**WELWYN HATFIELD BOROUGH COUNCIL  
EXECUTIVE DIRECTOR - PLANNING, PUBLIC PROTECTION AND GOVERNANCE**

**DELEGATED APPLICATION**

**Application No:** 6/2018/2827/PN8  
**Location:** 40 Astwick Avenue Hatfield AL10 9LA  
**Proposal:** Prior approval for the erection of a single storey rear extension measuring 6m in depth, 3m in height and, 2.8m to the eaves  
**Officer:** Ms Emily Stainer

**Recommendation:** Prior Approval Refused

Drawing number	Revision
15165-PRE-02	0

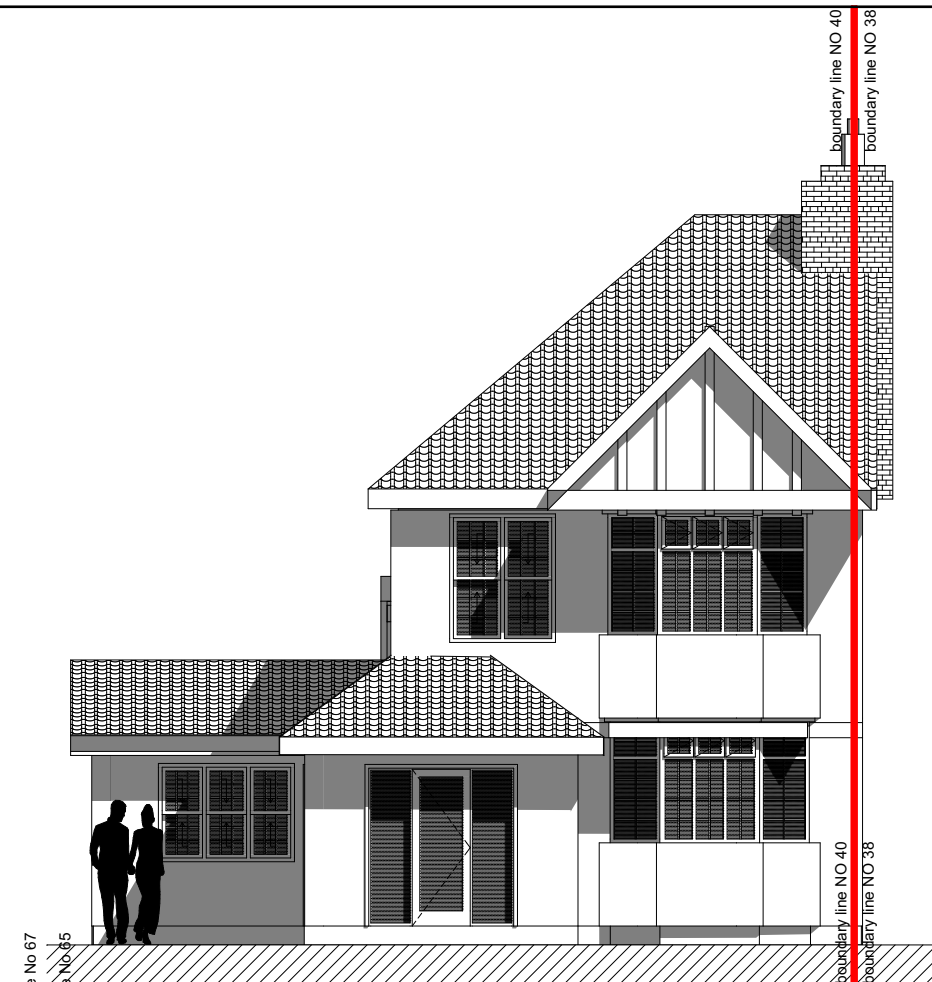
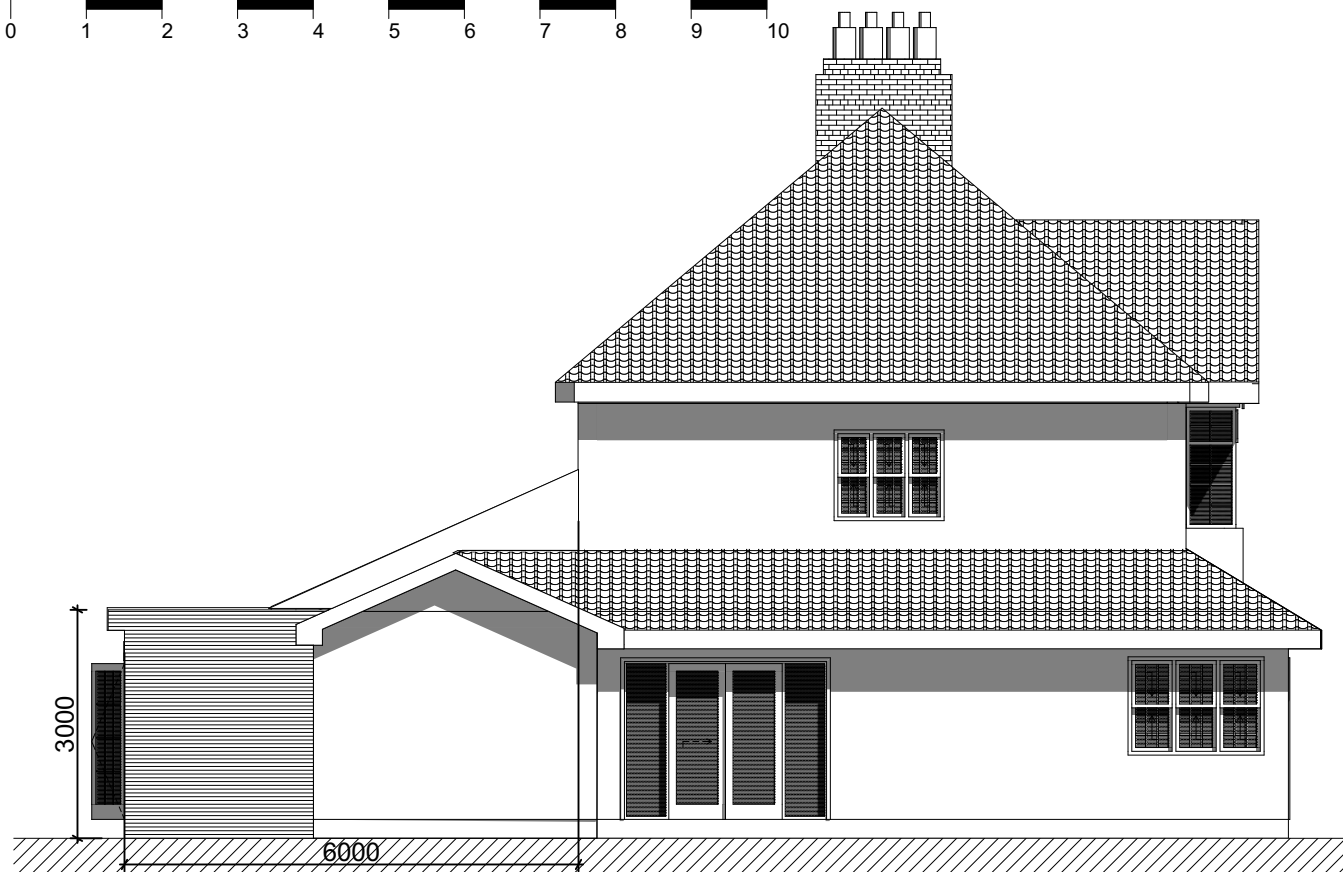
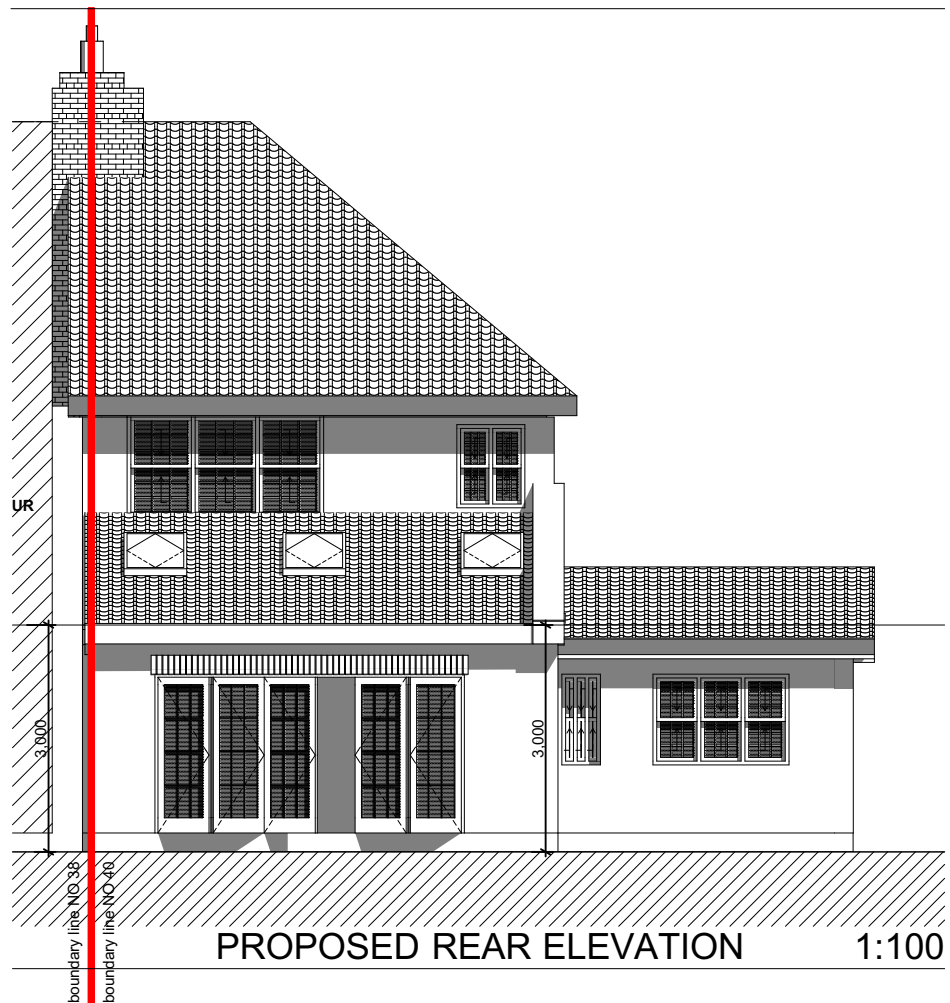
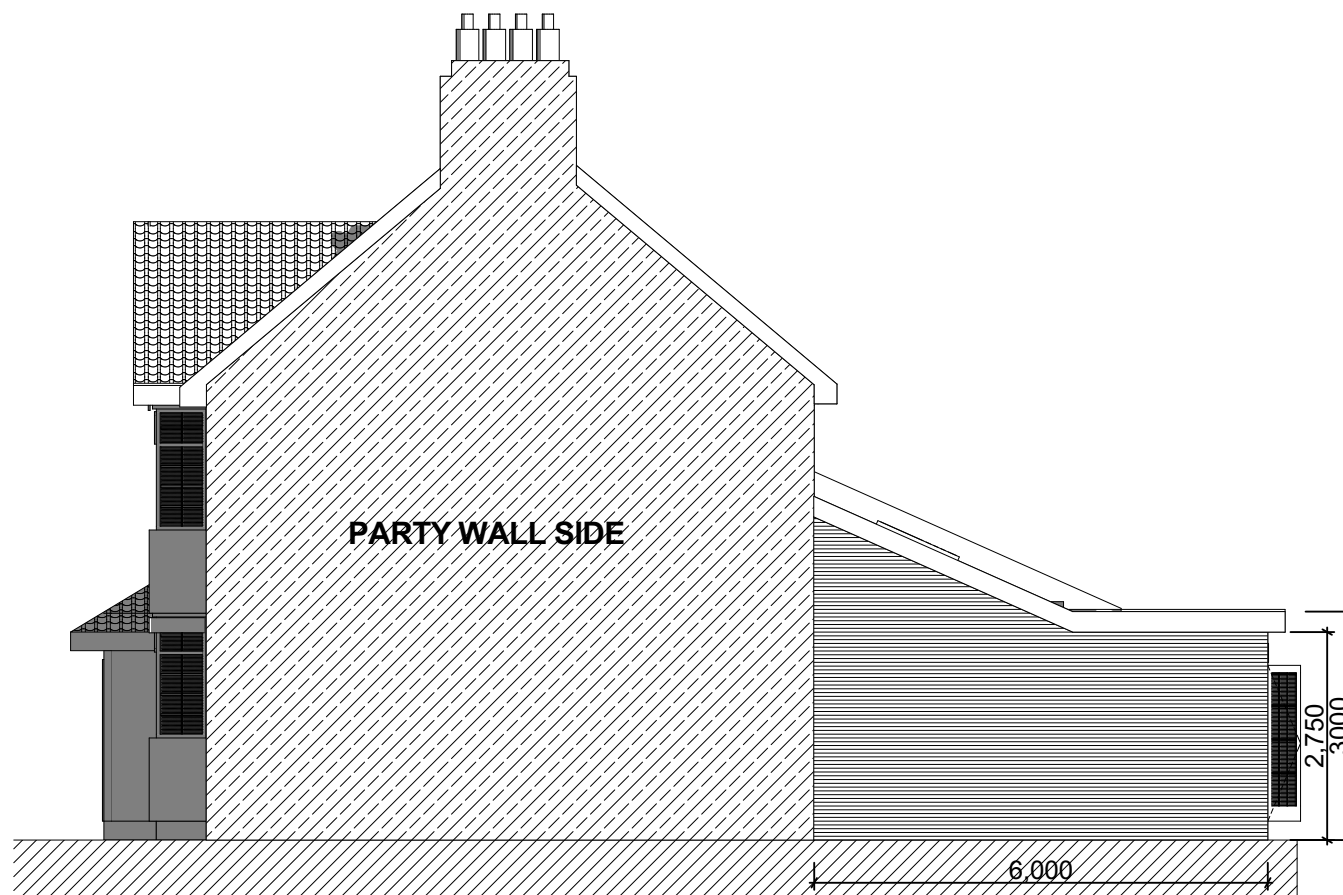
In this instance, as the proposed extension would join to an existing extension, it is important to firstly assess the proposed extension and then subsequently, the combined structure. When assessing only the proposed extension, it is noted that this would meet with the relevant limits and conditions of A.1 (e) to (j), however, when assessing the proposed extension and existing extensions as a combined structure in line with the amendments to Class A of the GPDO 2015, the proposal would fail to comply with A.1 (ja). Planning application S6/1978/0200 granted permission for a single storey rear extension and S6/1989/0662/FP approved permission for a single storey front and side extension and addition of pitched roof to the existing flat roofed rear extension. These works have been implemented. The existing elevations demonstrate that the pitched roof addition to the single storey rear extension has increased the ridge height to approximately 4.4 metres. There are discrepancies between the drawings however as proposed plan 15165-PRE-02 Rev 0 shows the ridge height to measure approximately 4.5 metres. The plan also includes the addition of a parapet to the side of the roof measuring up to 4.9 metres in height. While the proposed addition would have a maximum height of 3 metres, it would be attached to the approved rear and side extension. By virtue of this attachment, the combined structure would have a total height of approximately 4.9 metres and therefore would exceed 4 metres in height, would extend beyond a wall forming a side elevation and have a width greater than half that of the original dwellinghouse. The proposal would exceed the limits set out in paragraphs (e) to (j) would therefore fails to comply with A.1 (ja).

1. The total enlargement (being the enlarged part together with any existing enlargement of the original dwellinghouse to which it will be joined) would exceed the limits set out in paragraph A.1 (e) to (j) and therefore fails to comply with paragraph A.1 (ja) of Schedule 2, Part 1 of the Town and Country Planning (General Permitted Development) Order 2015. The application for prior approval is refused.
